DECISION DELEGATED TO DEVELOPMENT MANAGER

Application No: H16-0782-20 **Applicant:** Mrs A Darragh
Proposal: Front Porch Extension
Location: 46 Pennygate Spalding
Terminal Date: 12th November 2020

3091 - 06 rev A

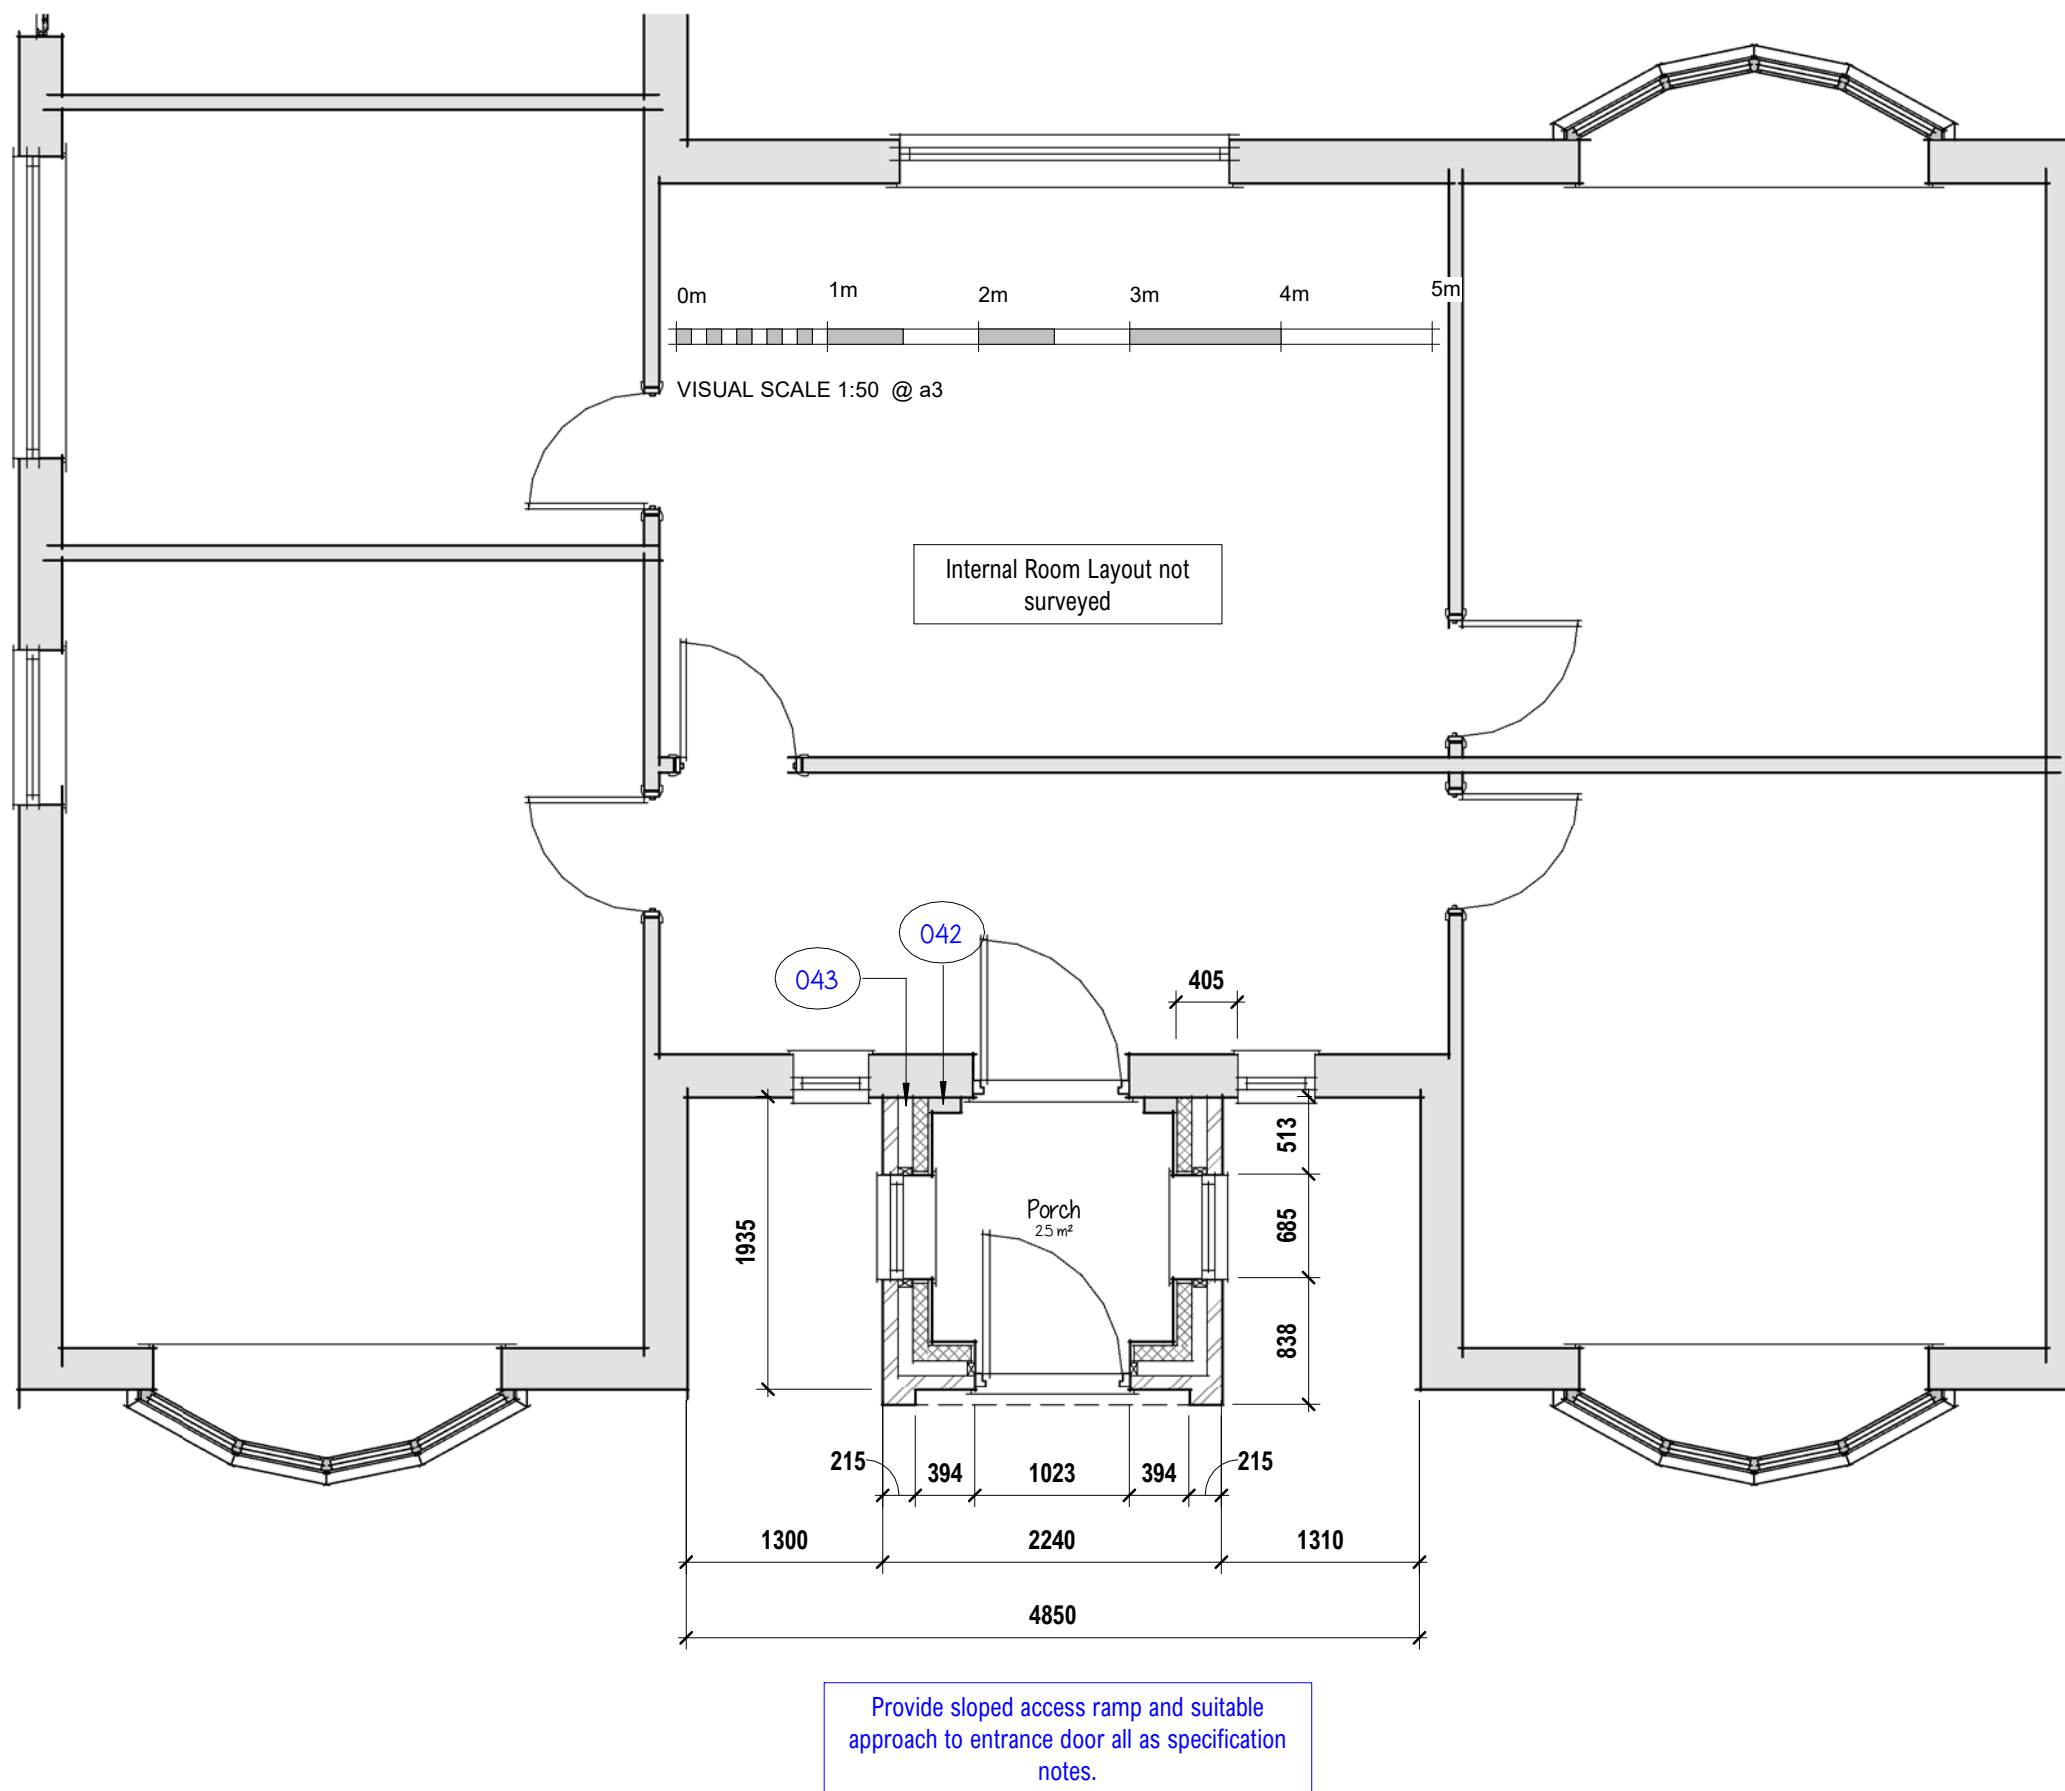
The proposed front extension will protrude approx. 1.9m from the front elevation recess and the width will be approx. 2.2m. The proposed eaves height will be the same as the existing eaves height of the bungalow but the ridge height would be lower than the two existing forward projections. The hipped roof structure will compliment the existing hipped roof structure of the bungalow. In view of the proposed dimensions, it can be concluded that the development appears to be subservient to the host property in terms of scale, mass and bulk.

This addition to the current bungalow will provide a front porch, with proposed windows to both side elevations and also an new front door to the front elevation of the bungalow.

The proposed single storey front porch extension does not protrude any further than the existing front elevations and is not higher than the host property. The windows to the sides of the proposed porch will not have an adverse impact upon overlooking due to the existing protrusions of the front elevation and the bay windows. It is therefore not considered that the proposal would have a material adverse impact on residential amenity in terms of overlooking, overshadowing or having an overbearing effect.
